Sent: Tuesday, May 14, 2024 12:24 PM To: Ben Taylor <Ben.Taylor@ribblevalley.gov.uk> Subject: Objection To Application Ref 3/2024/0269

Re:- Application Ref 3/2024/0269

Proposed change of use of ground floor unit (Use class E) and first floor flat (Use Class C3) to House in Multiple Occupation with up to eight residents (Use Class Sui Generis) including removal of shop front and replacement with two ground floor windows and addition of new door and window to side elevation.

Ground Floor Unit and First Floor Flat 27-29 Bawdlands Clitheroe BB7 2LA

Client: Boutique Homes Ltd		
Project: Proposed Alterations 27-29 Bawdlands Clitheroe		
Dwg title: Proposed Rear Elevation		
Scale @ A3: 1:50	Date: 04.03.24	Drawn by: PD
Drawing no. 1569 - 12		Rev. -

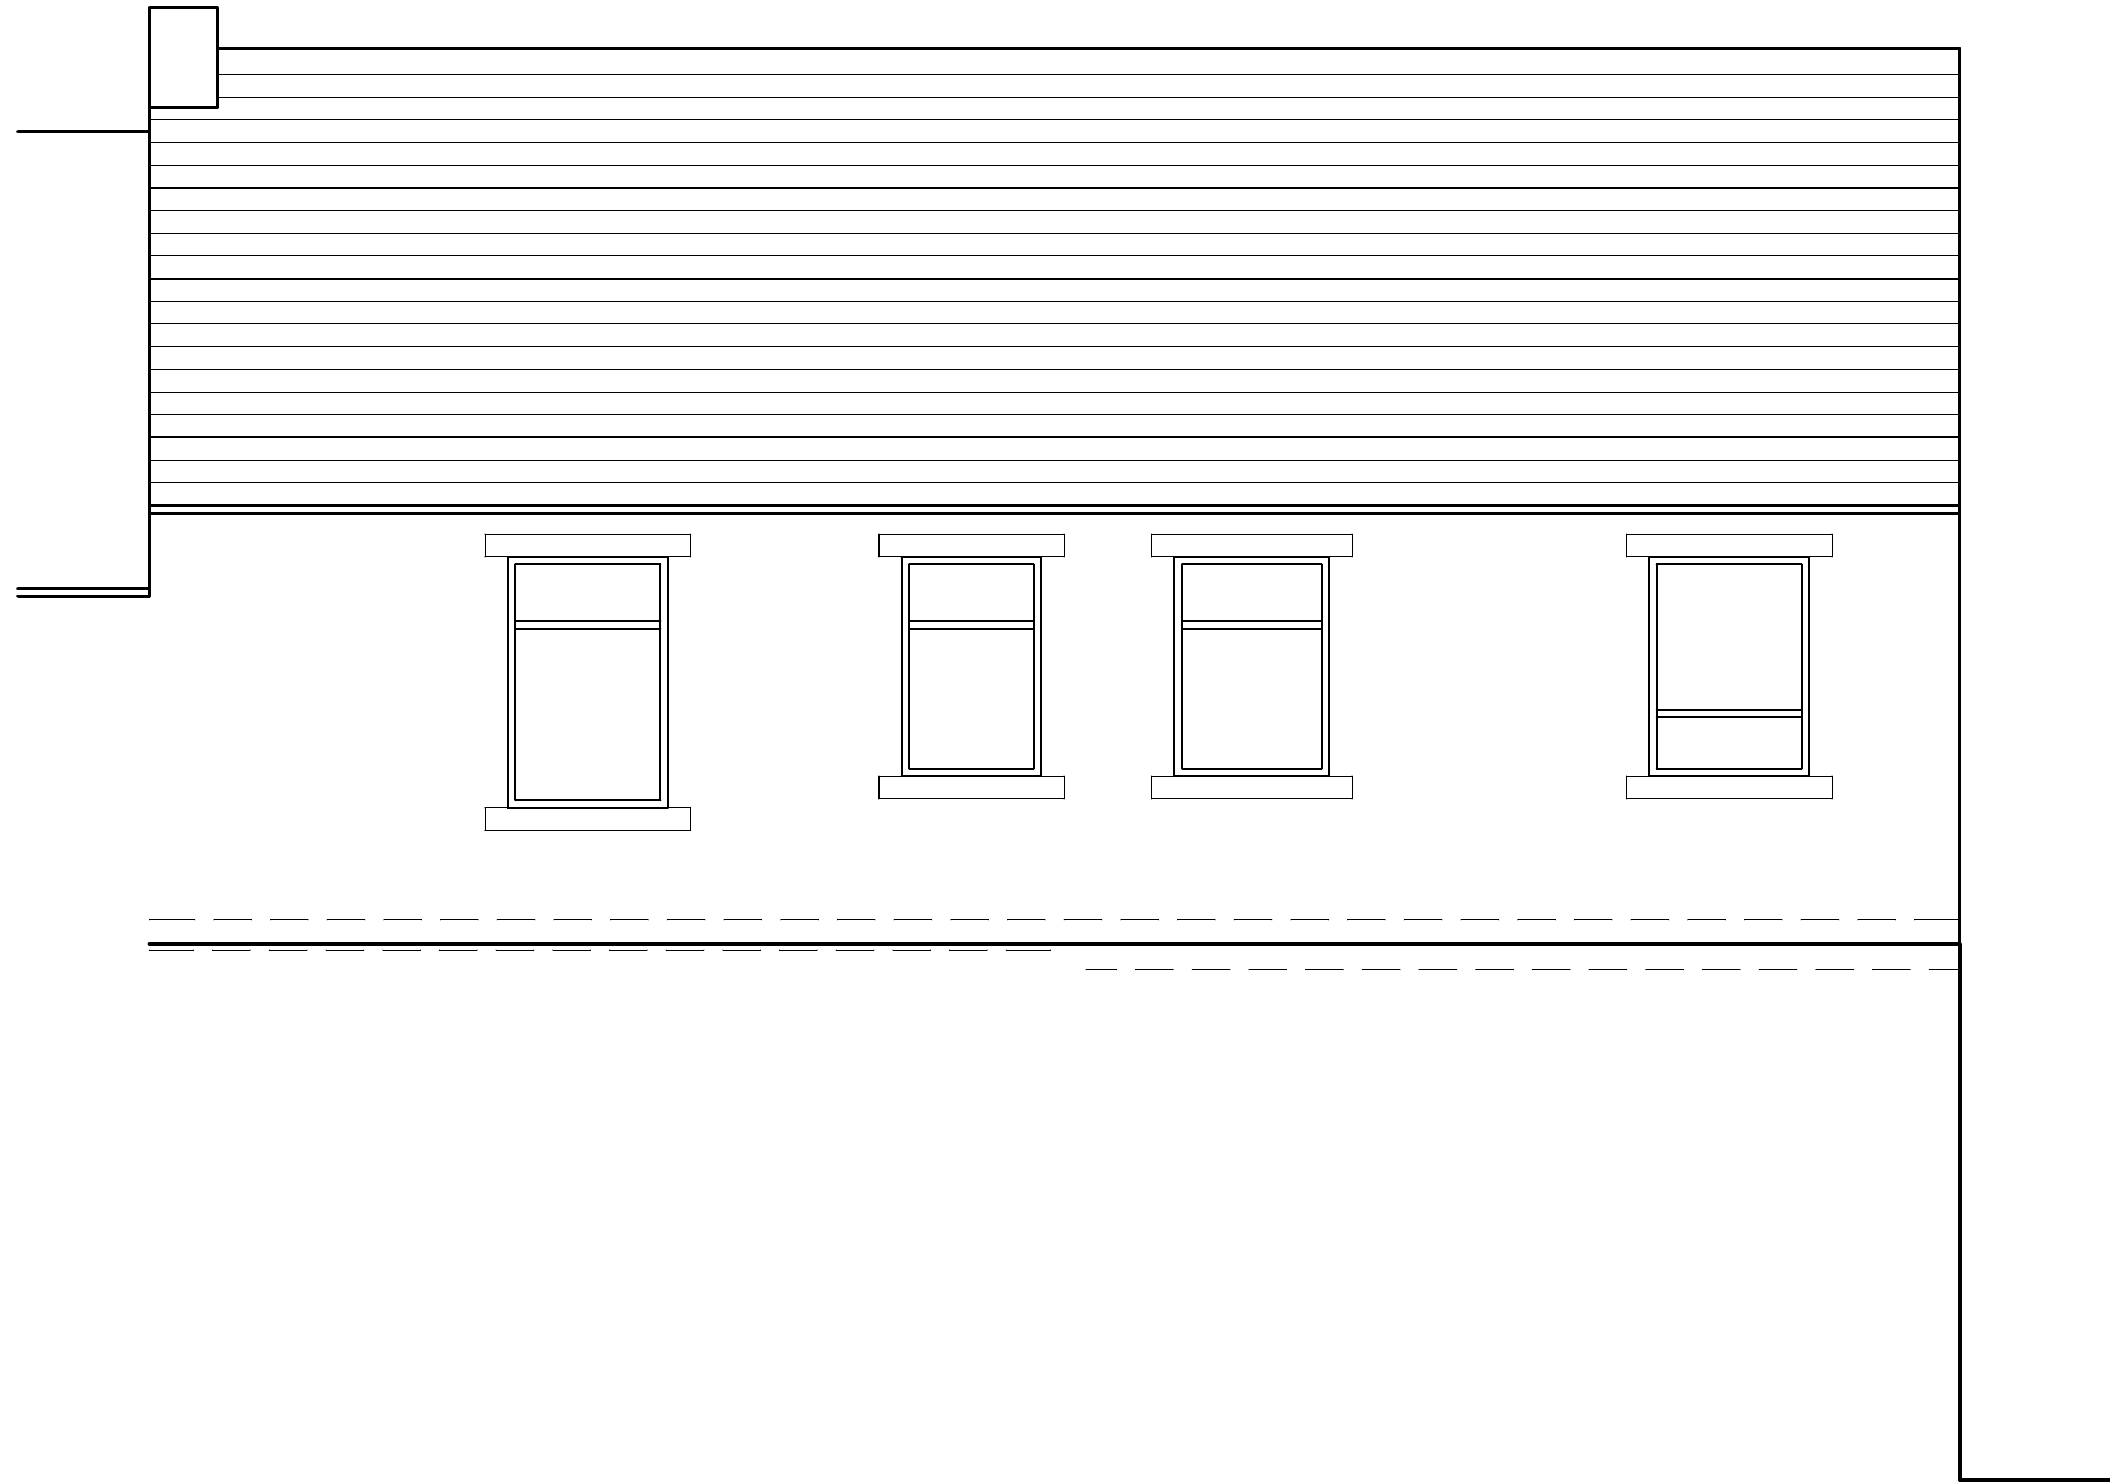
5.3: With regard to the windows to the rear elevation (Staircase, Units 6 & 7). Directly attached to the rear elevation is the Gym referred to in the previous planning applications. As this Gym is now under separate ownership and of a different Use Class (following the LPA approval of application Ref 3/2022/1080), these windows are directly on a boundary wall and there may be a requirement for these to have a designated level of fire resistance. This would require that the windows do not incorporate opening lights which would result in units 6 & 7 being devoid of any natural ventilation.

Client: Boutique Homes Ltd		
Project: Proposed Alterations 27-29 Bawdlands Clitheroe		
Dwg title: Proposed Side Elevation		
Scale @ A3: 1:50	Date: 04.03.24	Drawn by: PD
Drawing no. 1569 - 11		Rev. A

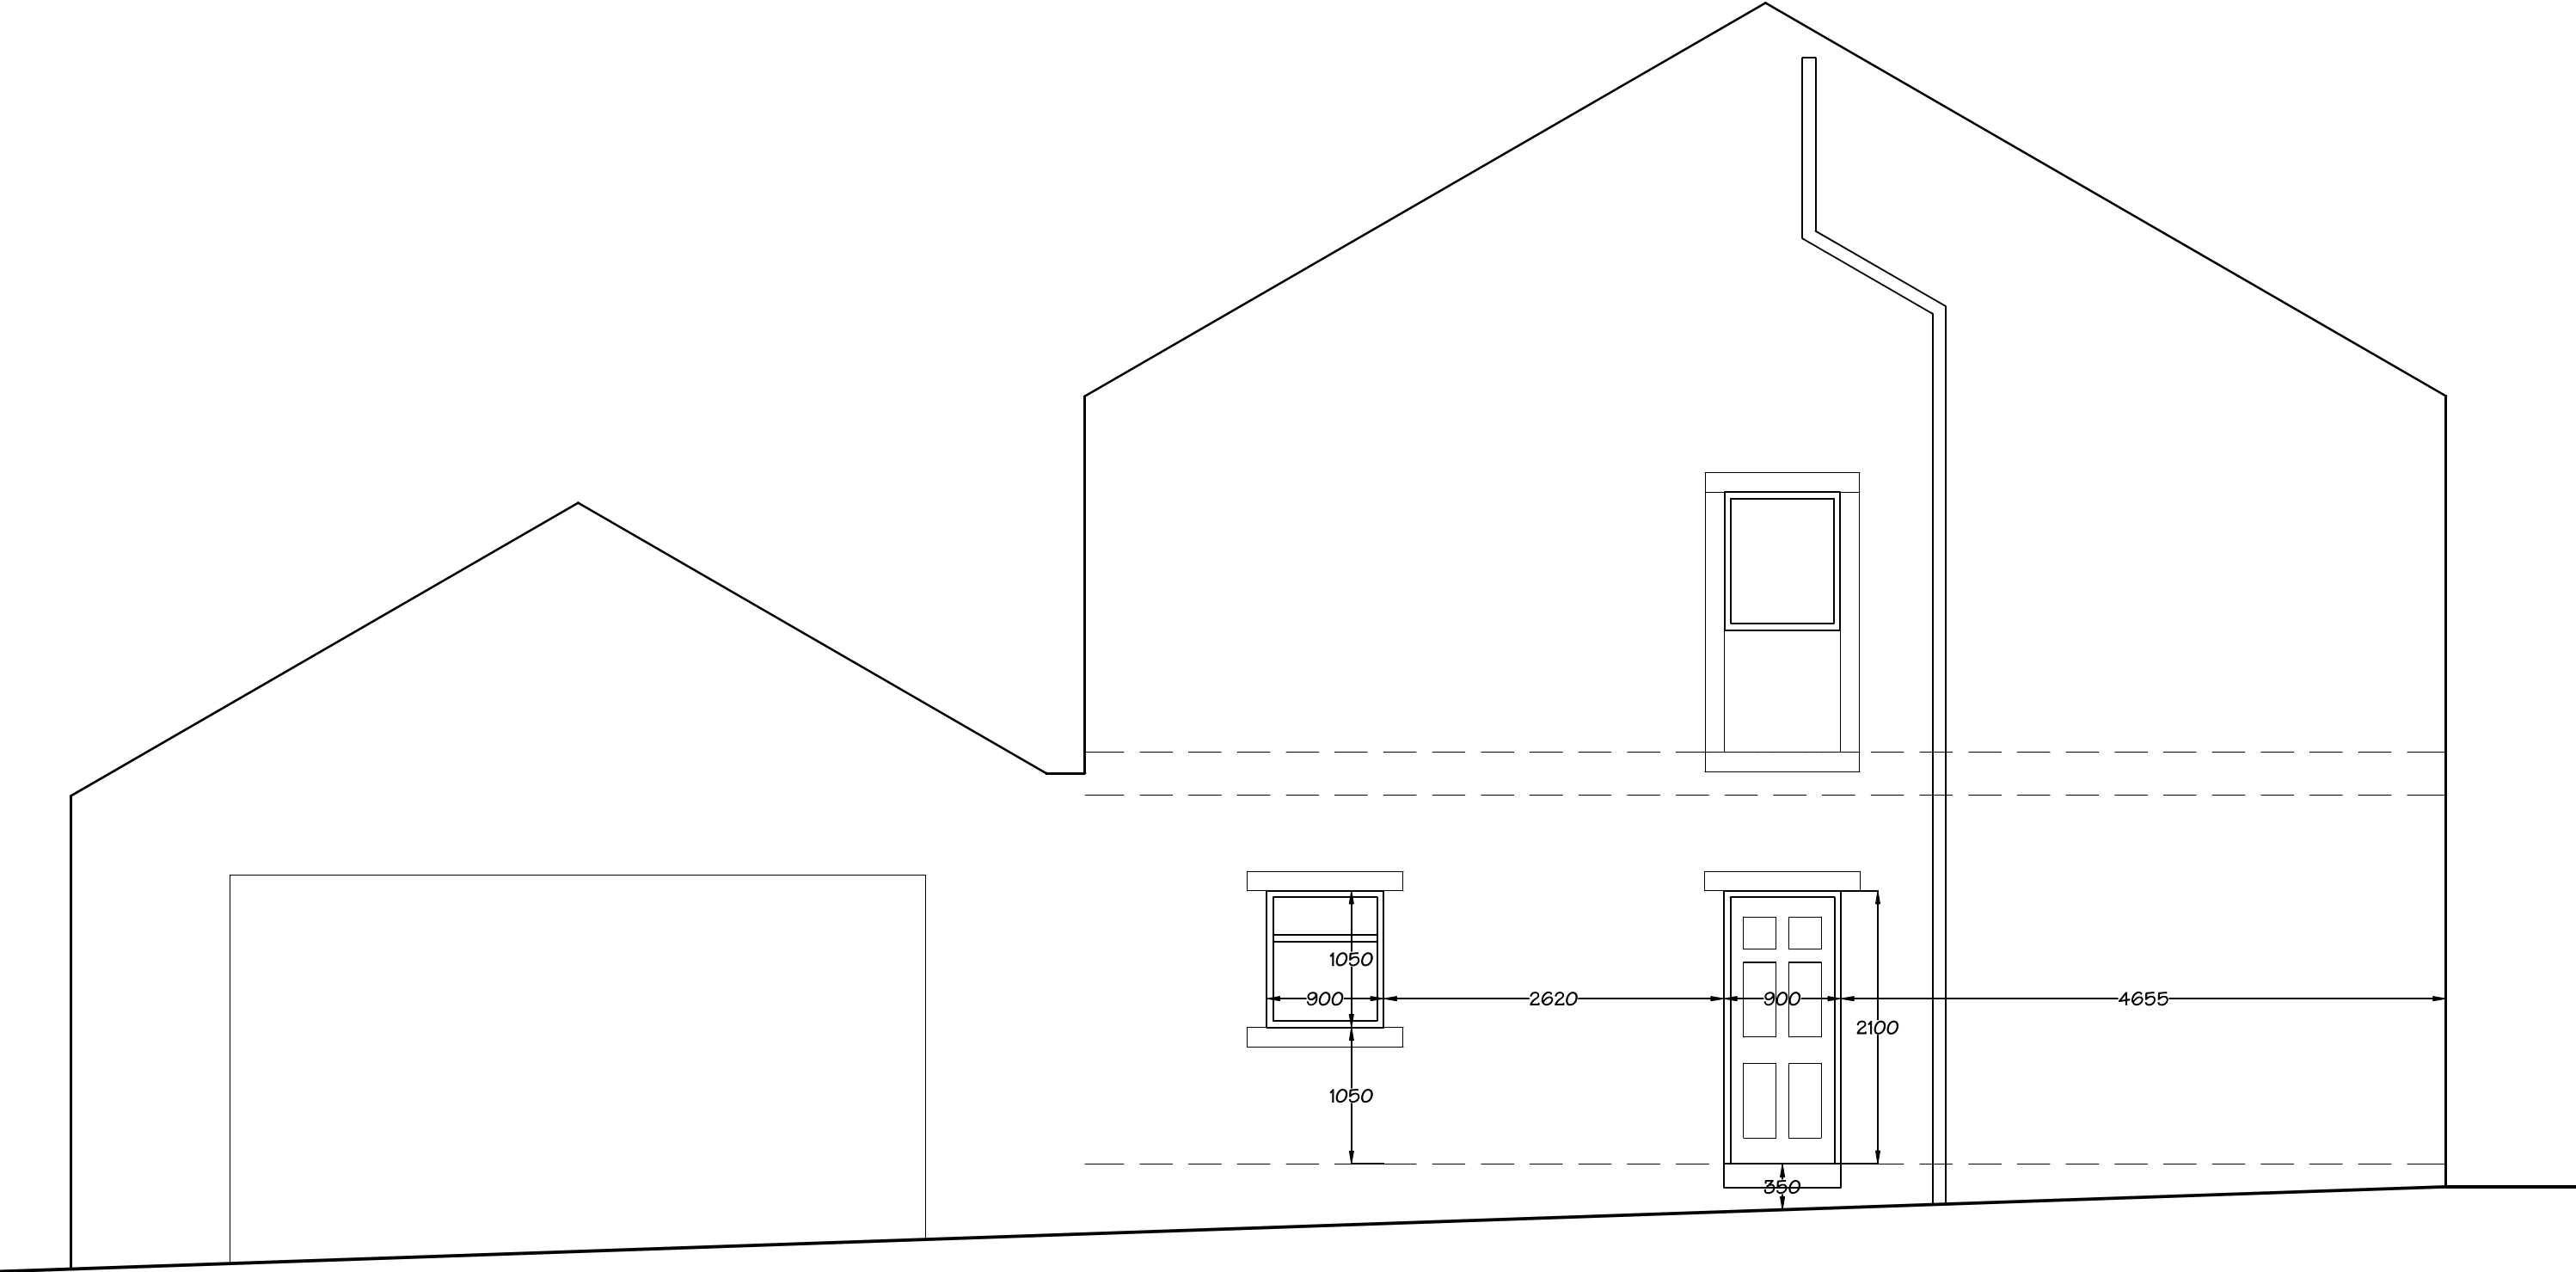
4.2: The external access to the Bin Store is proposed via the provision of a new doorway to the side elevation on Corporation Street. At the new door position there is a single step indicated on the Proposed Ground Floor Plan with 2 steps indicated on the Proposed Side Elevation, along with a dimension of 350mm from the pavement to the internal floor level. Given the painted plinth line along the side elevation this 350mm dimension would appear to be a rather conservative estimate, with the actual difference in levels being around 500mm at the worst case. A 500mm difference would necessitate the provision of a minimum of 3no steps to comply with Building Regulations requirements. Even considering 2no steps, these would have to be positioned within the curtilage of the building and not form an obstruction over the pavement, the knock on effect would be reduced space within the already very limited Bin Store.

4.3: National Standards suggest that there should be level access to refuse bins as it is considered that the moving of bins up and down steps is difficult, cumbersome and dangerous. It is also a concern that for ease of use, and to avoid the movement of bins up and down steps, the bins could be left outside permanently (as is the case in other areas of the Ribble Valley) to the detriment of the visual amenity of existing residents and blocking of the pavement to the wider populate. The necessity for the refuse bins to be stored inside the curtilage of the buildings structural fabric, once again highlights the lack of any external space or ancillary storage and emphasises the unsuitability of the overall proposal.
